Application No: AB/45/20/HH
Site Address: 19 Priory Road Arundel BN18 9EJ
Description of works: Roof alteration from hipped roof to front and rear gable in order to create additional rooms in the roof. Erection of decking in the rear garden (extension of the proposed works to the approved application ref: AB/129/18/HH).

Thank you for your internet representation made on 27th June 2020 which has been recorded as no objection with the comments as follows:

Proposed Side South Facing Elevation

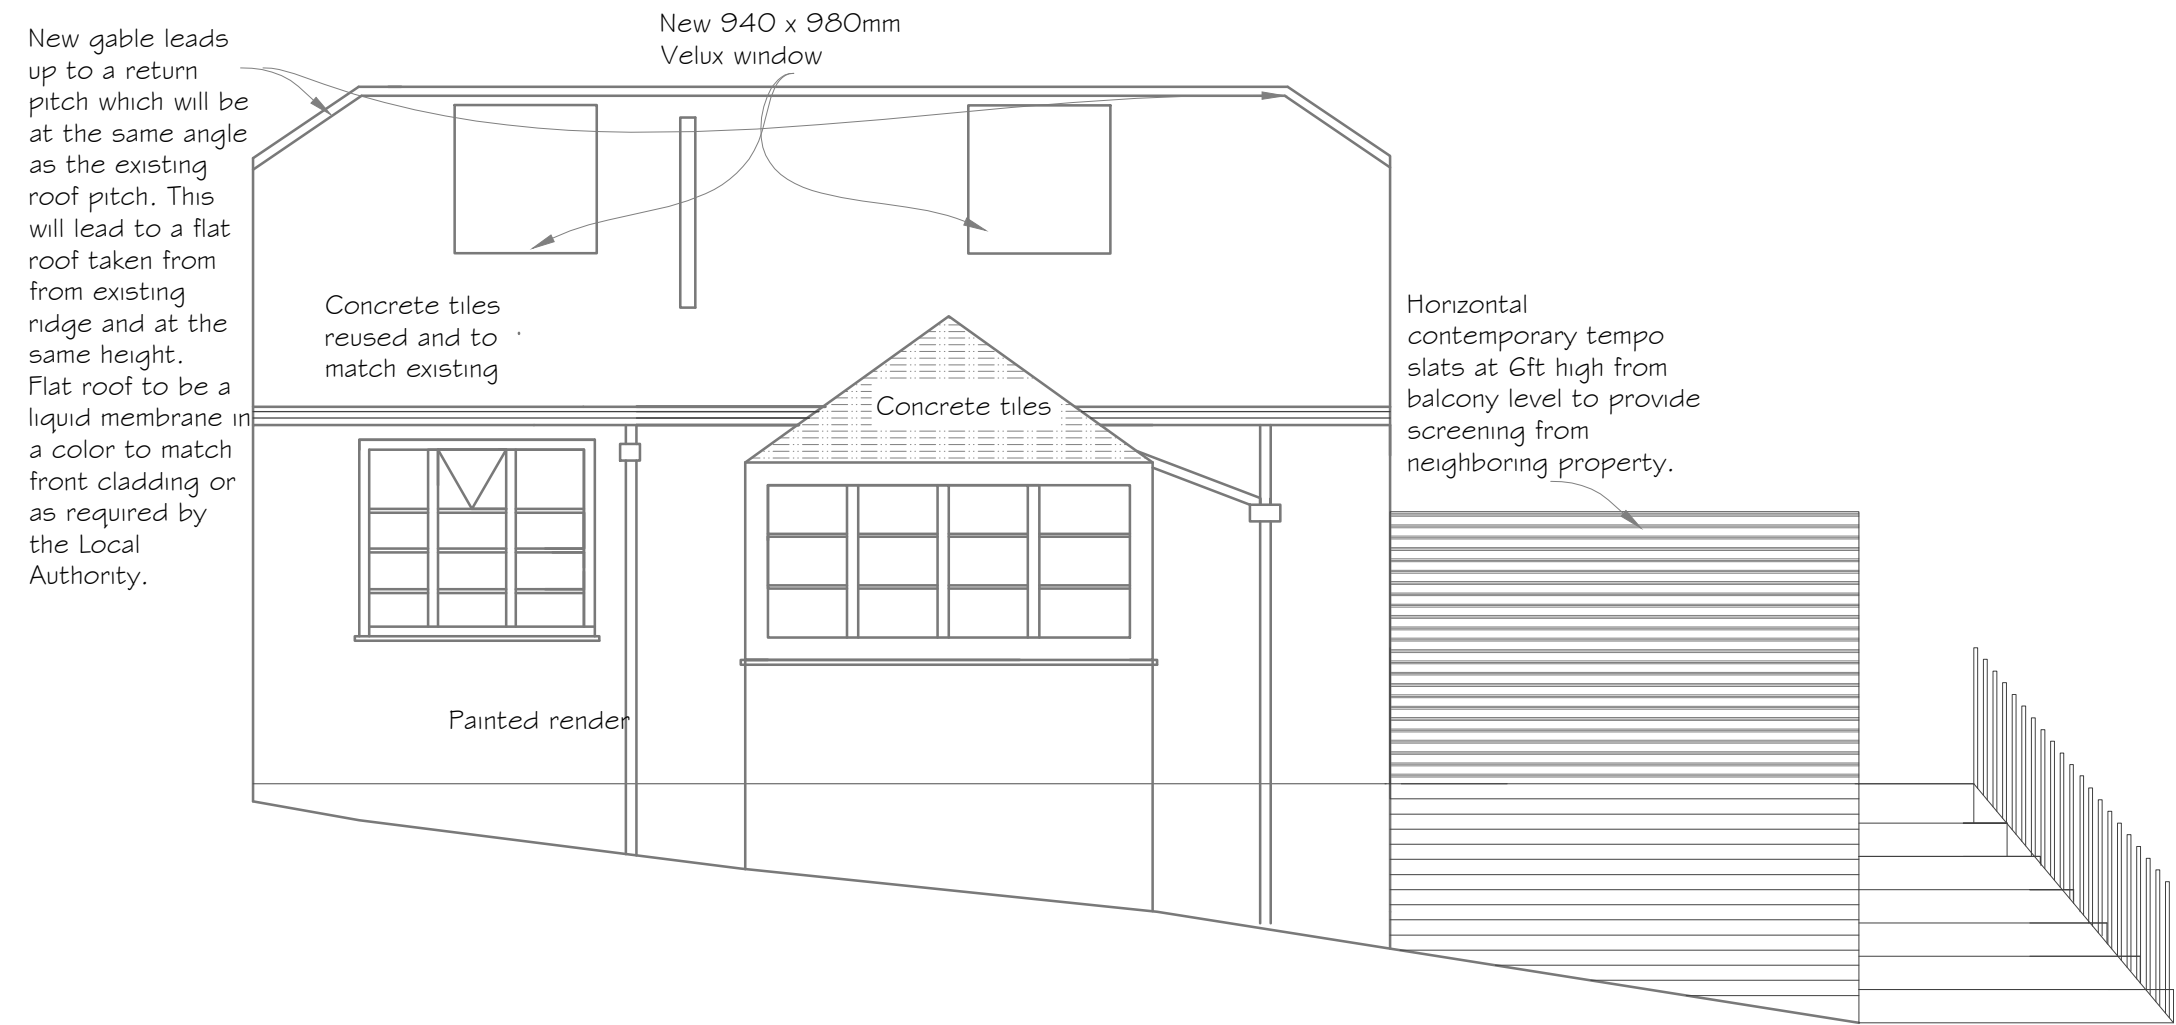
We don't object to the extension, however have some concerns over privacy, as our clear glass bathroom dormer window will be at a lower elevation than the two new dormer windows on the proposed South facing side elevation. This might possibly result in direct views into our shower. If this proves to be the case we would request that frosted glass to be used on the new windows as appropriate.

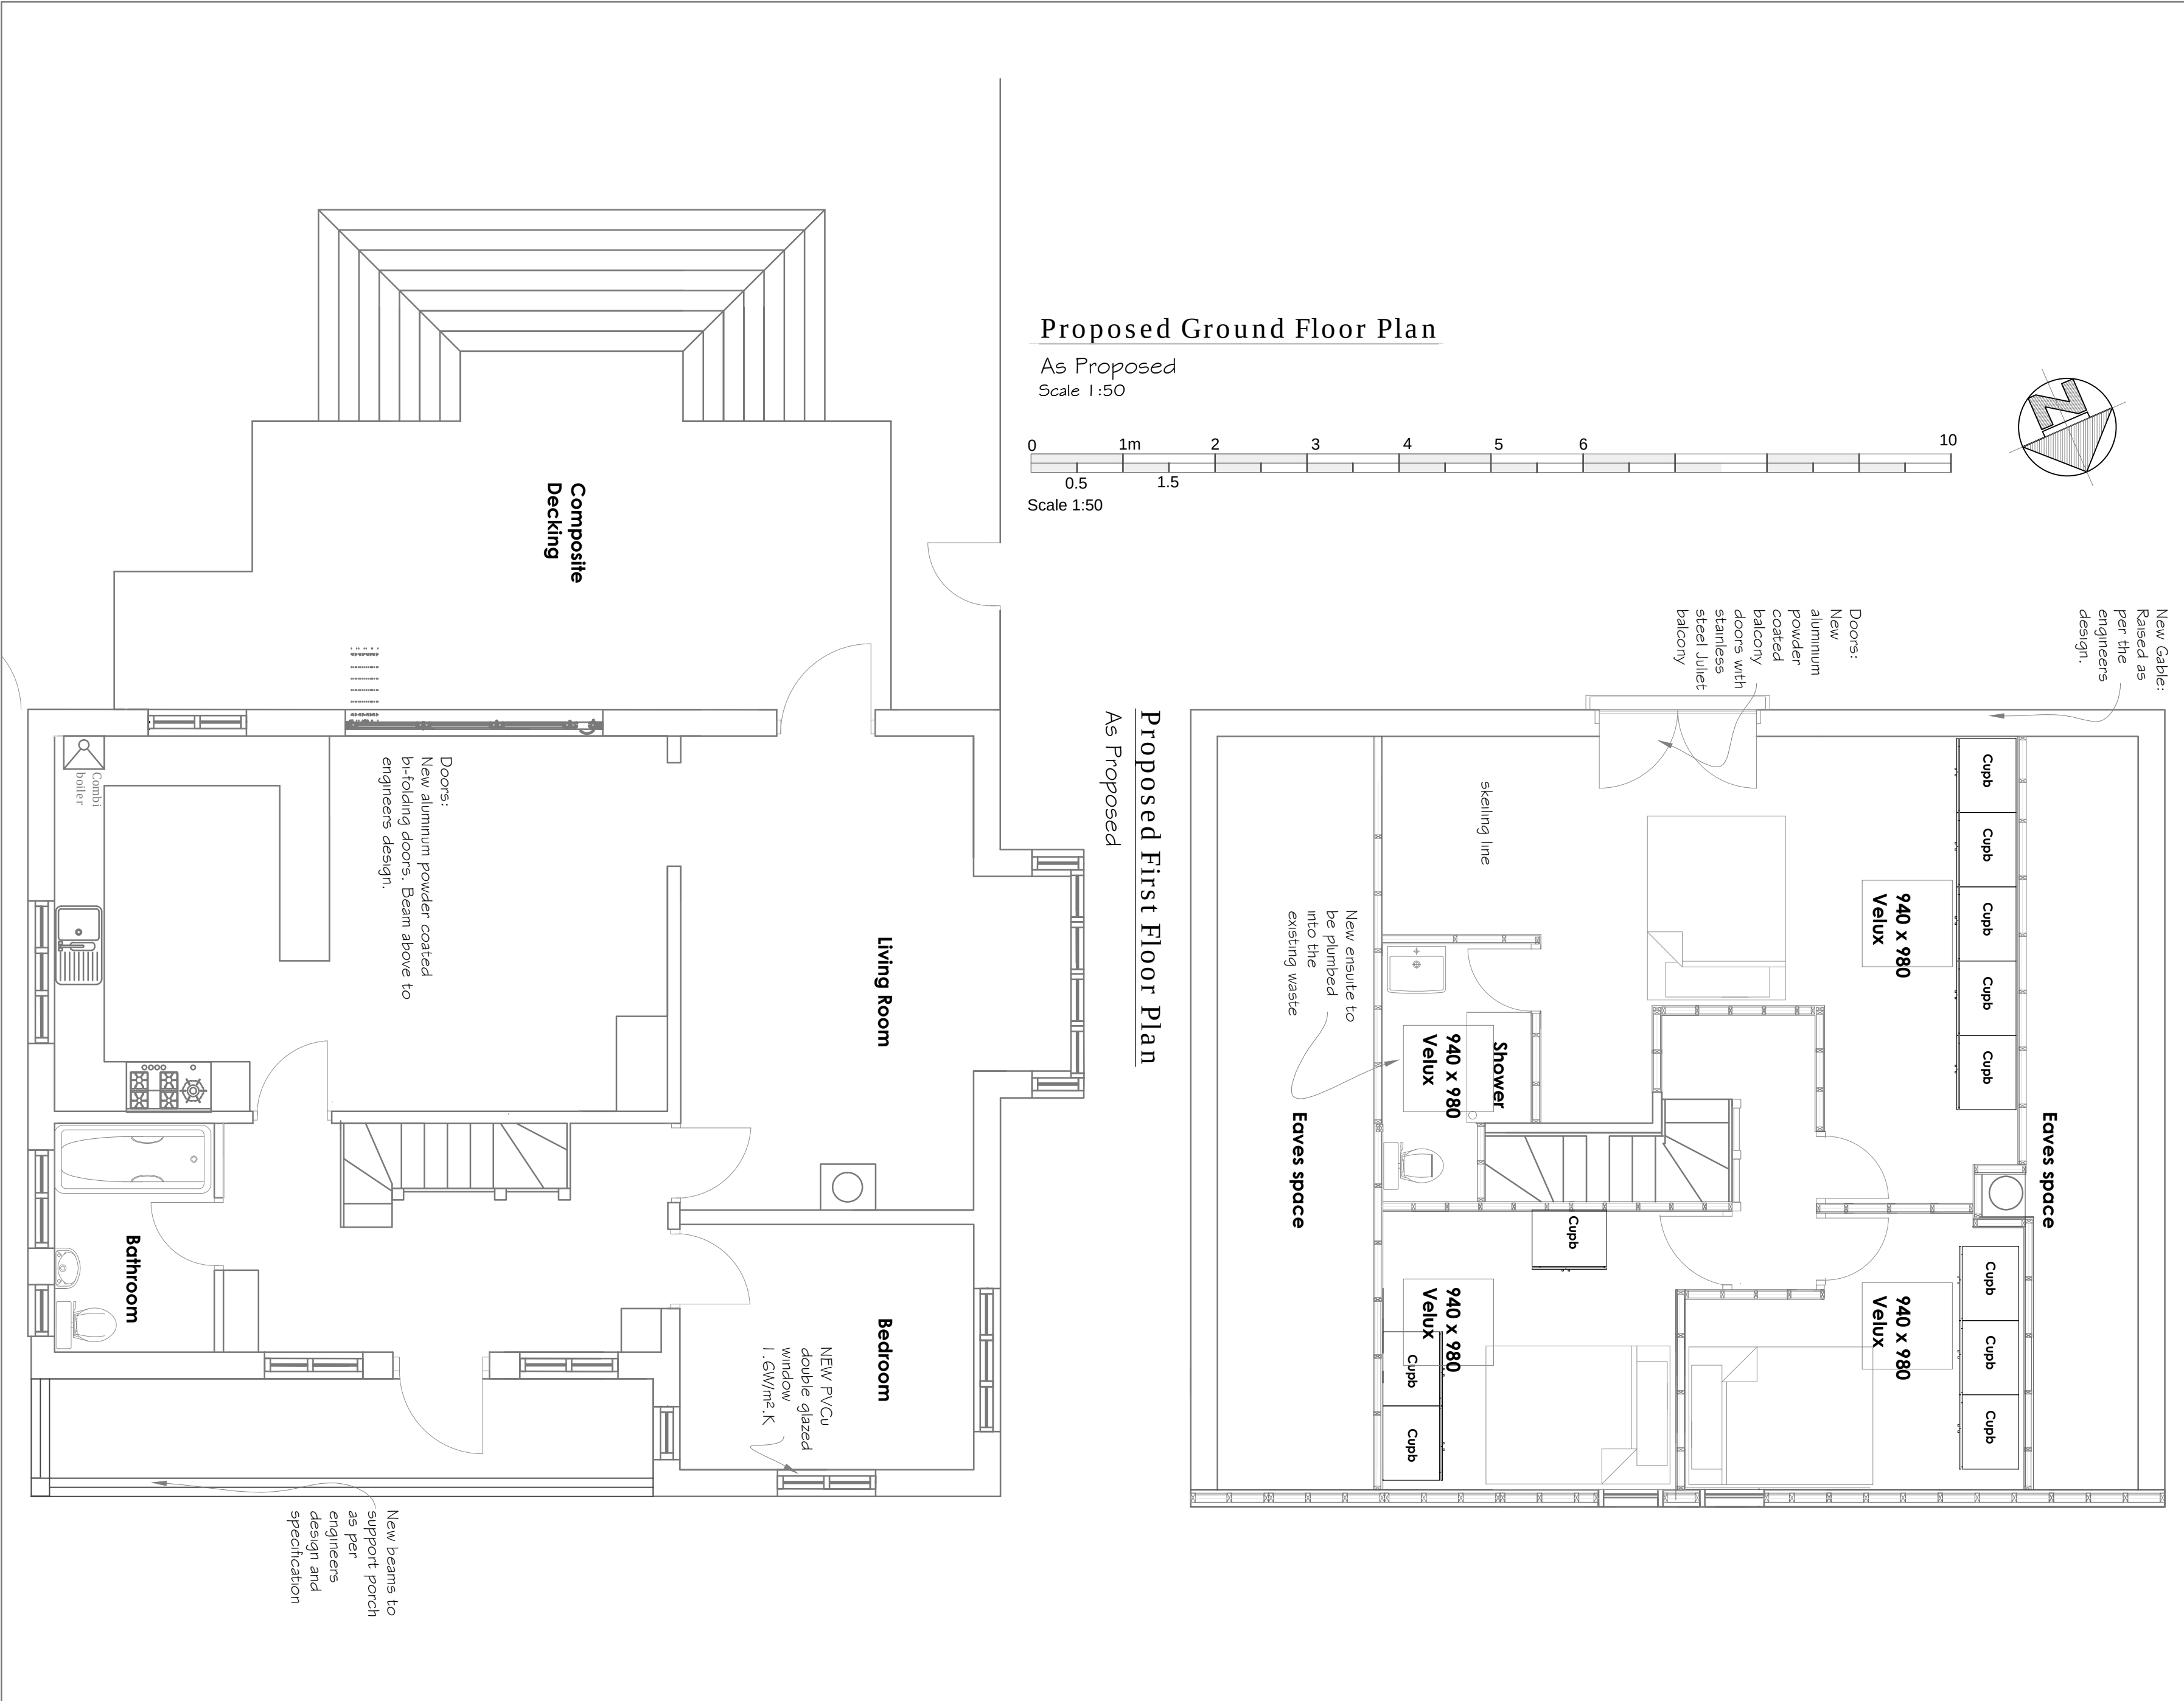
With regard to the 6ft slatted privacy screening 'to provide screening from neighbourhood property' we ask that this provide screening for us as well. This will be important as the new decking level and extent will overlook our garden more than previously. Please ensure slatting gaps provide sufficient privacy to us.
